An
Bord
Pleanála

Inspector's Report ABP-312301-21

Whether the material alteration to fenestration and the provision of a substantial deck/platform is or is not development and is or is not exempted development.

Fanaghans, Inver, Co. Donegal.

SUSPENDED DECK / PLATFORM OUTLINED IN YELLOW
 MAKEUP ALTERATIONS TO FENESTRATION CIRCLED IN RED

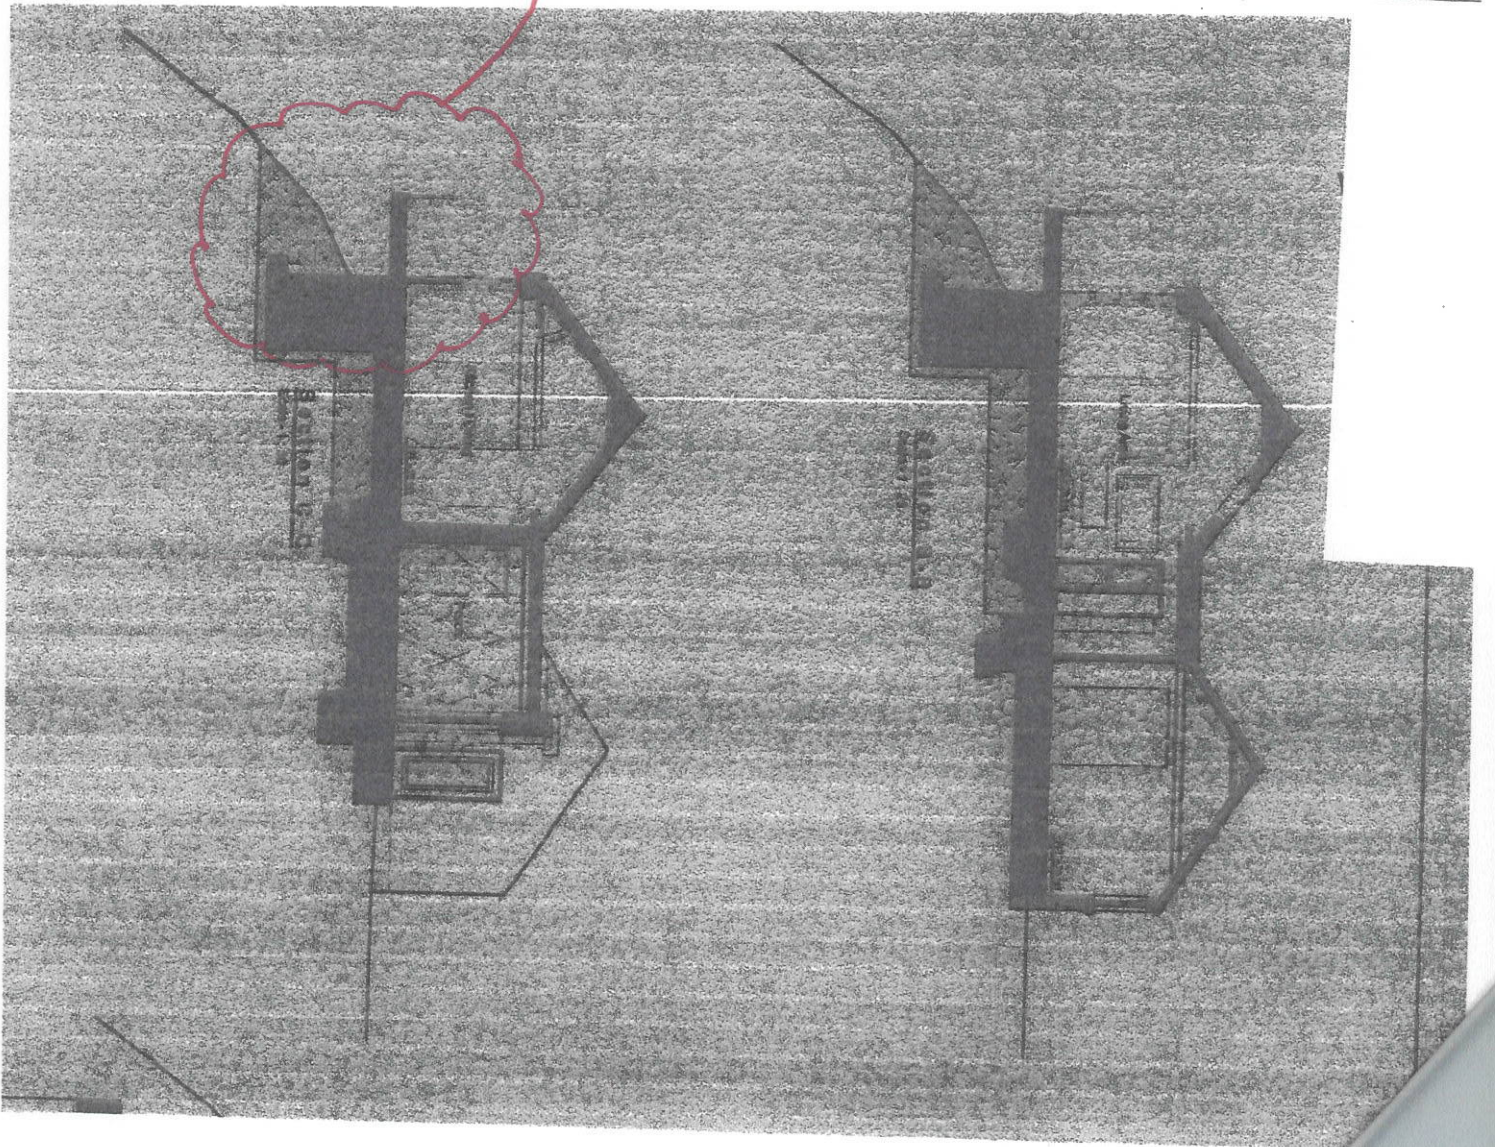
8.3.6. Secondly, the deck/platform is, as discussed above, a suspended structure, the main purpose of which is to afford sea views either directly from it or indirectly over it from the extension itself. The owners/occupiers state that it should be regarded as exempted development under Classes 5 and 6 of Part 1 of Schedule 2 to Article 6 of the Regulations. This position can be critiqued on the following grounds:

- The Classes cited are only operative within curtilages. The owners/occupiers appear to assume that the deck/platform is sited within the curtilage of the dwelling. However, they have not established that this is so. *Prima facie* the former presence of a ranch style fence may have marked the south-eastern extent of the curtilage that served the un-extended dwelling. The deck/platform projects beyond the line of this fence, as illustrated in drawing no. 2020-025-P01.2, and so it is sited in a position outside the curtilage.

- The deck/platform is suspended above ground level and its primary use is for viewing. As such it has the character of a balcony, rather than a path or a hard surface as cited in Class 6. By the same token, its seaward side is enclosed by means of a glazed balustrade, rather than a railing, wall or fence as cited in Class 5. Accordingly, the deck/platform with its glazed balustrade do not come within the ambit of the descriptions of development in Classes 6 and 5.

DRG. 2A

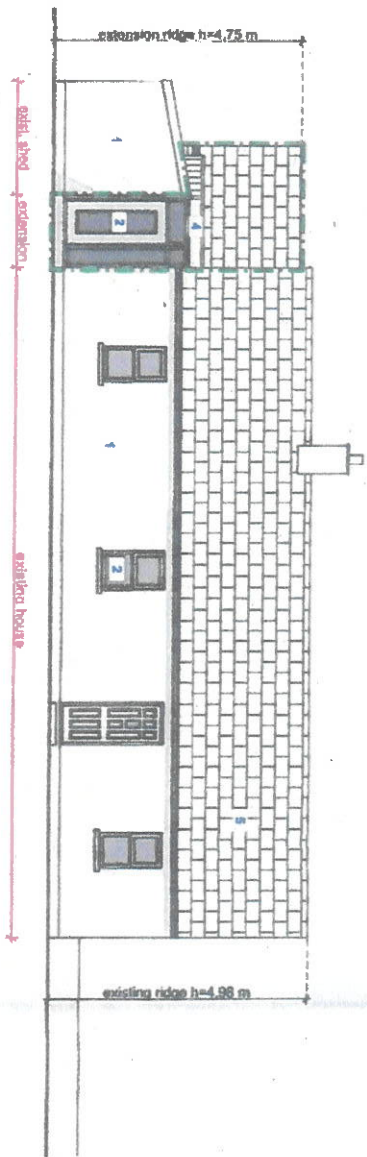
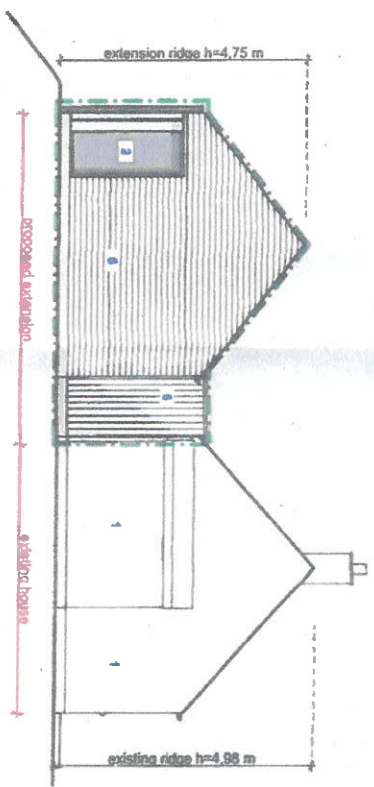
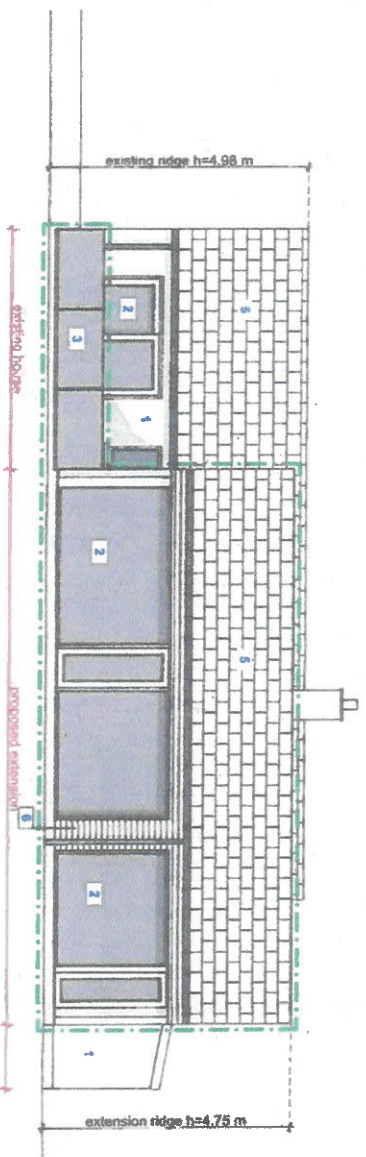
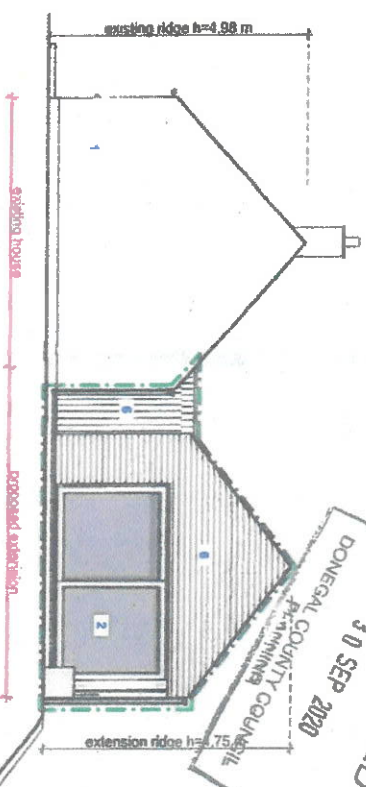
- With respect to the fenestration in the extension,
 - The glazing in the south-western elevation of the extension is shorter than permitted,

- A 550mm wide timber clad insertion to the south-eastern elevation has been omitted in favour of glazing,
- The eastern corner glazing has been reduced in height by the insertion of a 500mm high wall beneath the glazing, and
- Two sliding glazed doors have been installed in the south-eastern elevation.
- With respect to the rear of the extension and the rear of the patio to the side of the extension, the provision of a substantial suspended deck/platform with a 1.1m high glazed balustrade.

8.3.5. Firstly, the changes in fenestration. The first three of these changes set out above have only the slightest effect upon the emerging aesthetic of the extension and so I consider that they would come within the ambit of Section 4(1)(h) of the Act. The fourth change, too, has only the slightest effect upon the emerging aesthetic. However, as discussed above, the installation of sliding glazed doors in the south-eastern elevation presupposes the presence of the deck/platform and so they cannot reasonably be assessed in isolation from this deck/platform and the resulting pattern of access/egress/usage that they afford.

DRG. 3B

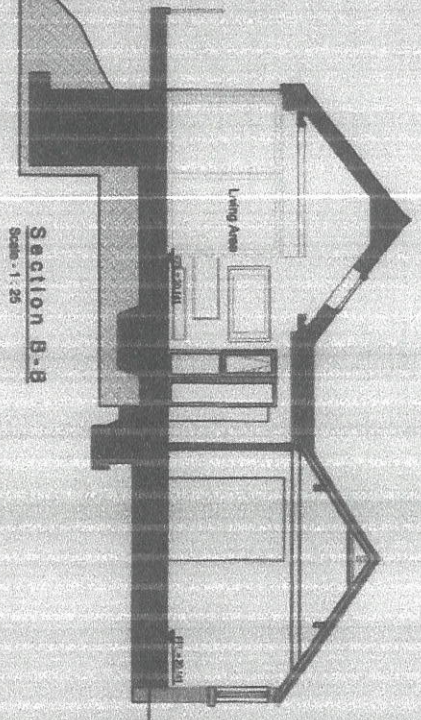
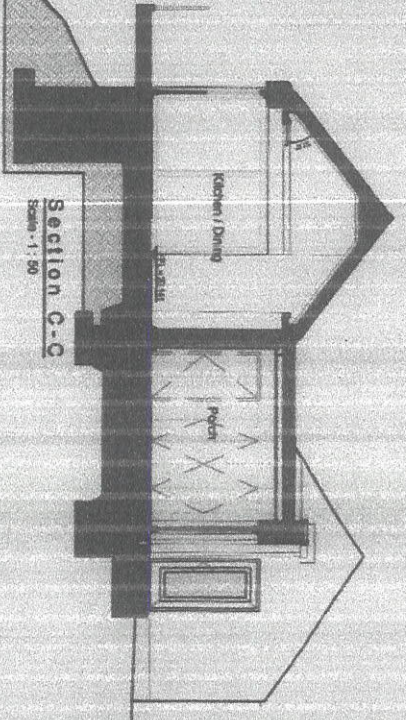
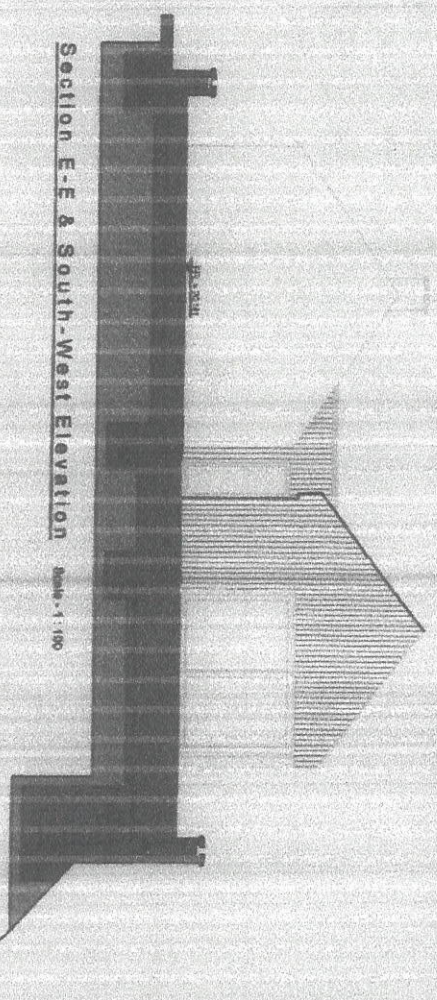
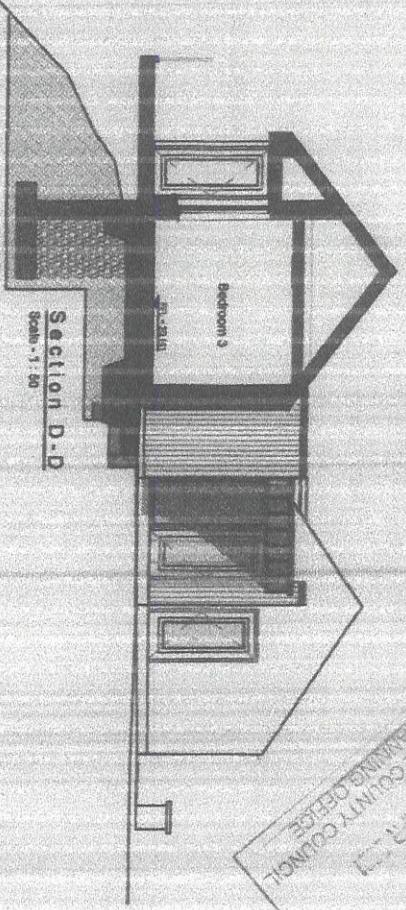
- Likewise, the underside of the deck/platform is supported by cantilevered steelwork which projects from the lower wall/foundation to the rear elevation of the extension. Photographs submitted by the referrer illustrate that this steelwork was installed as part of the construction of the lower wall/platform. Furthermore, photographs submitted by the owners/occupiers illustrate that the extension and the deck are designed to not only be used jointly, but the intended architectural floating illusion is created by this very combination, i.e., views from the extension over the deck omit any of the intervening coastline, thereby conveying a sense of being at sea.
